# Rezoning Transportation Analysis

Petition Number: 2021-176

Date	Description
11-19-21	First Review (TM)
12-17-21	Second Review (WB)

CONCEPTUAL REZONING PLAN

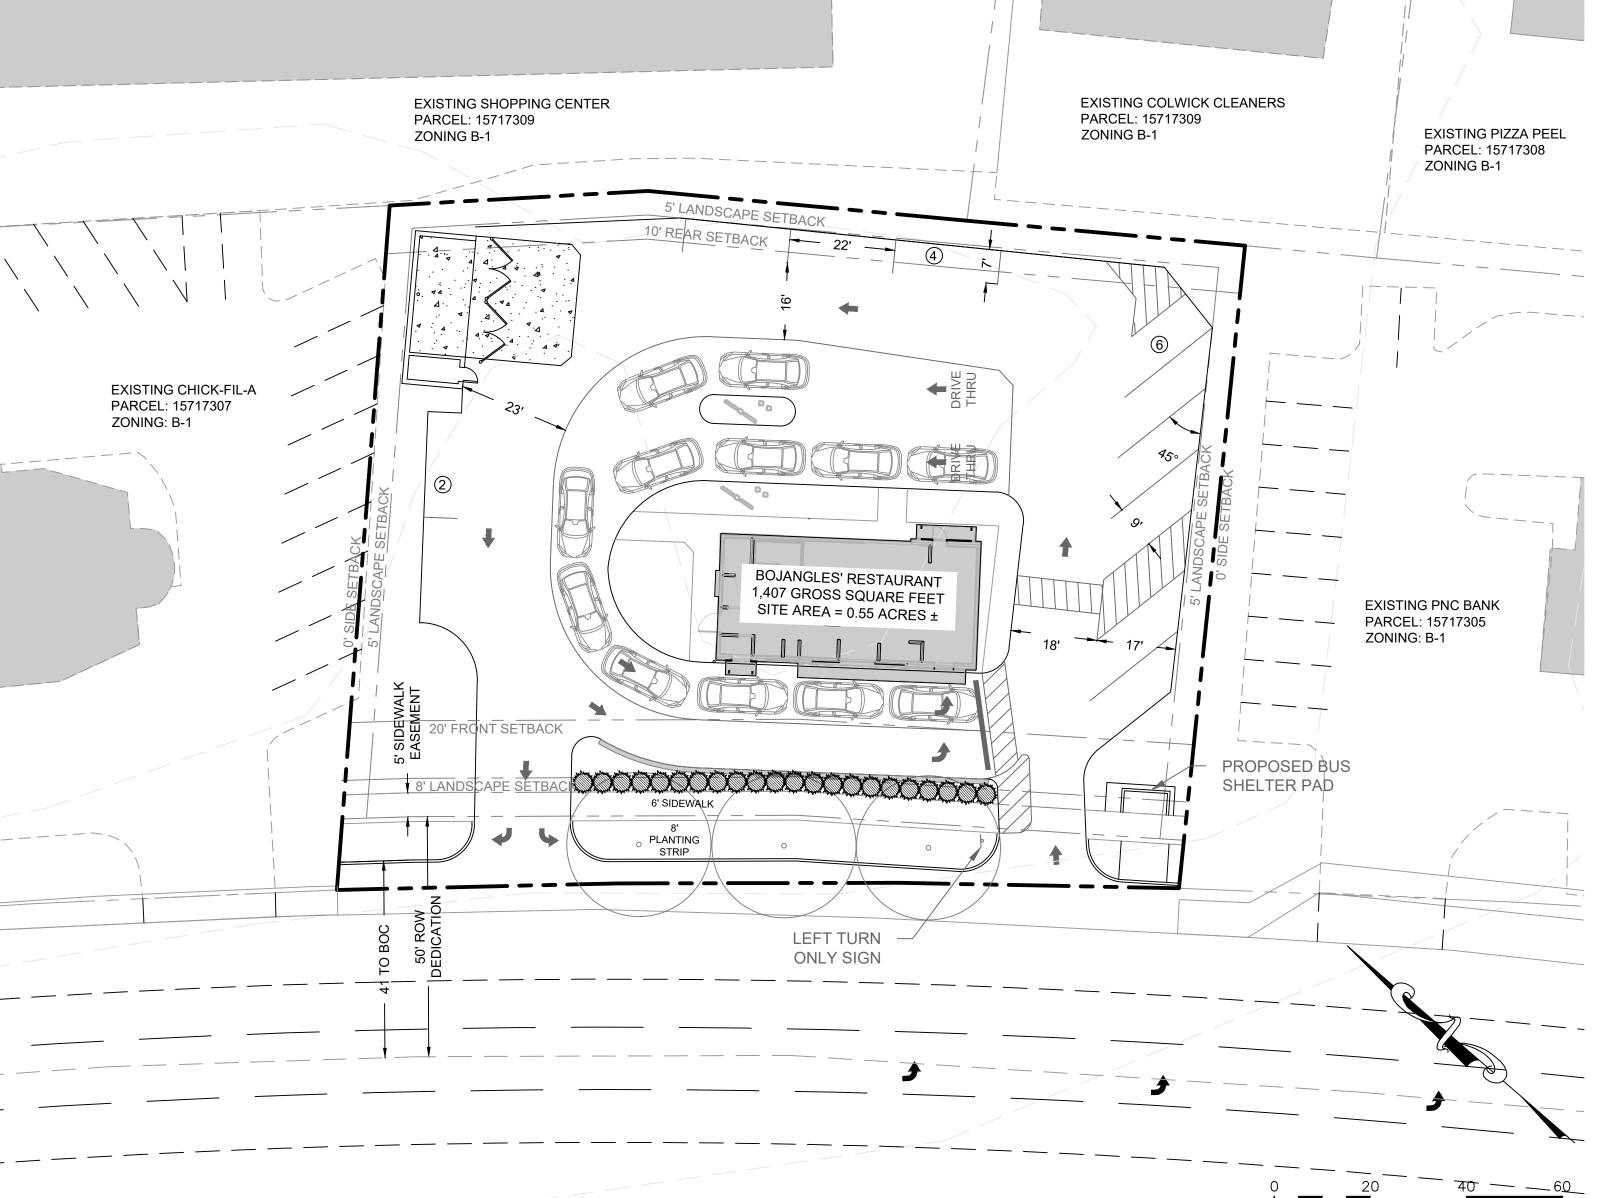
Revise site plan and condition note(s) to commit to removing the sidewalk transition to the south of the site along Randolph Road and continuing the 8-foot planting strip and 6-foot sidewalk to tie-in to the property's sidewalk. Revise site plan and condition note(s) to commit to transitioning proposed Curb and gutter, sidewalk, and edge of pavement, to tie into the existing facilities.
